From: Nicola Spencer
Sent: 25 April 2017 11:58
To: Planning.Responses
Subject: RE: Further Information Required on Your Ref: N/A Our Ref: BE/41/17/HH

Location Plan scale 1 : 1250

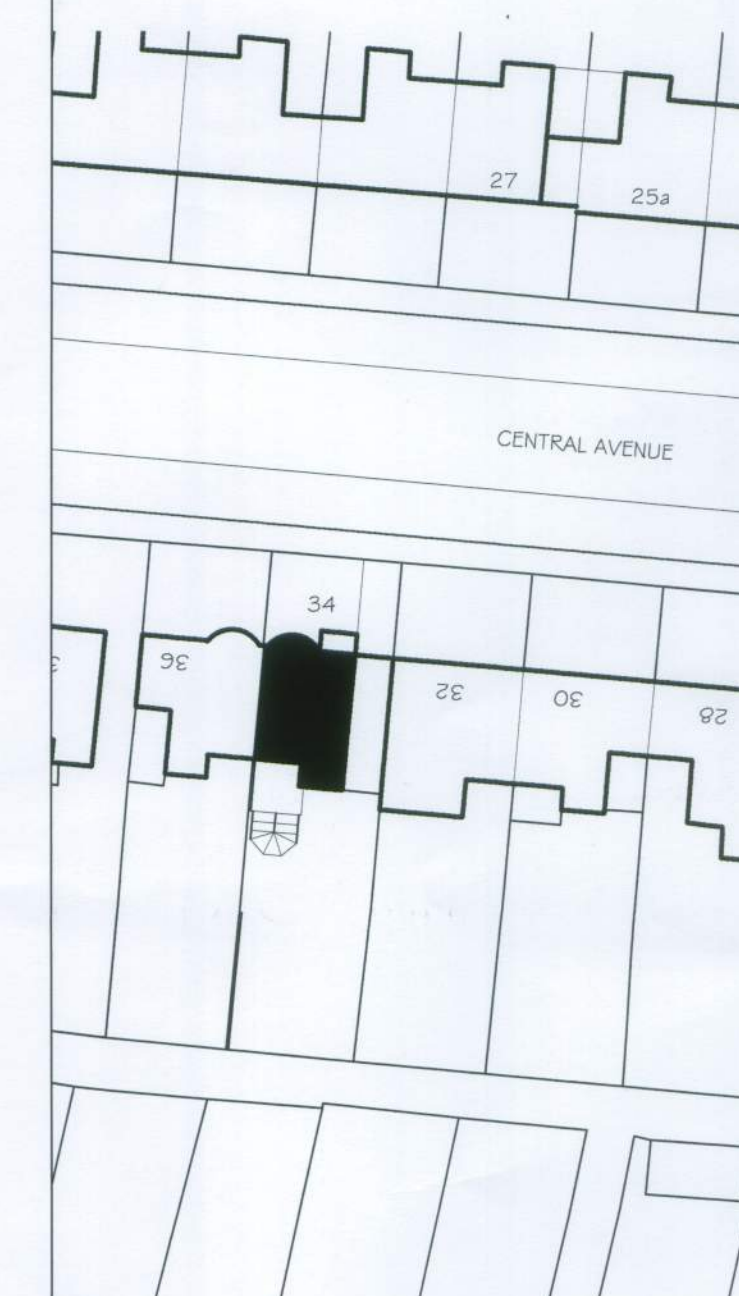
The copy that was scanned had not been red edged but I have arranged for the colour copy we have to be scanned, so this resolves the issue of the red edge on the location plan.

Site Plan scale 1 : 500

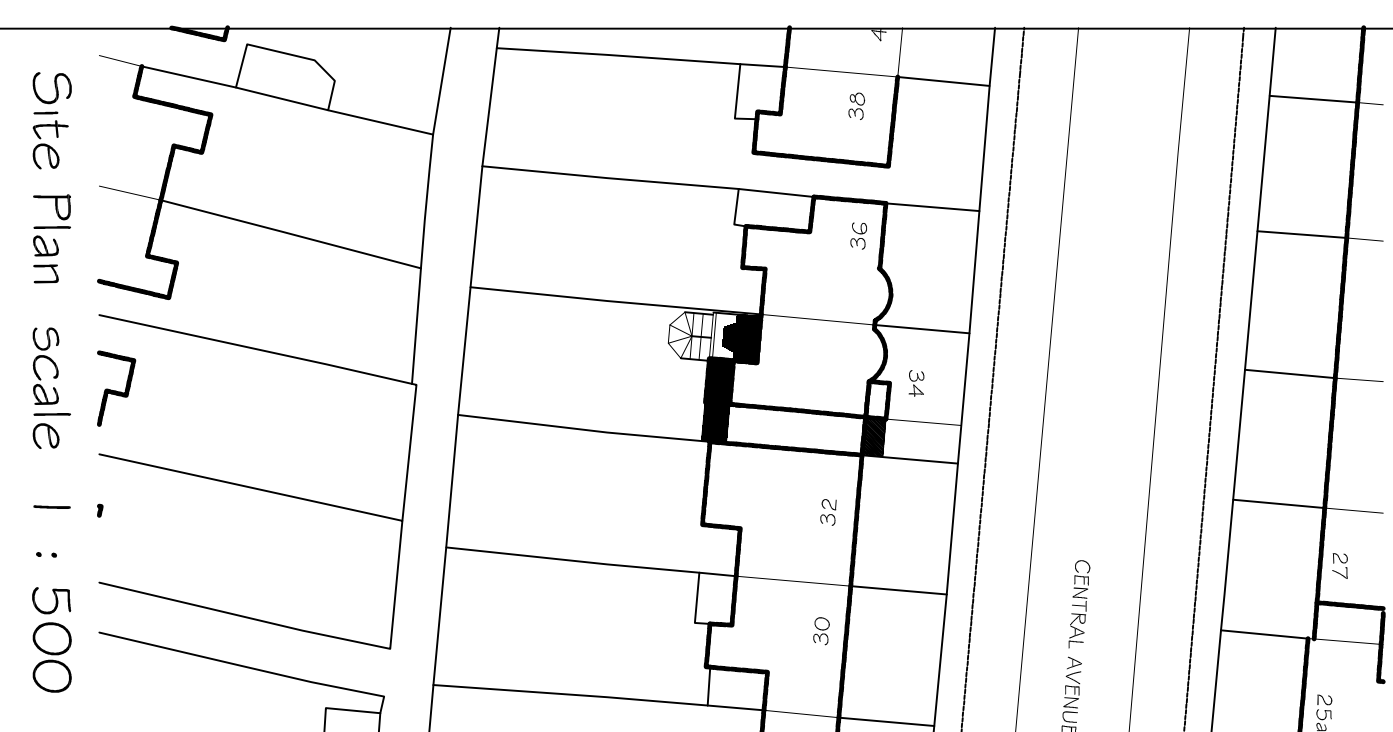
With regard to the distances to the boundary it appears that the ground floor extensions run up to the side boundary so I only require the distances from the proposed ground floor extension to the rear boundary and the distance between the proposed garage extension to the front boundary

On receipt of the amended block plan showing the dimensions to the boundaries we will be pleased to validate your application
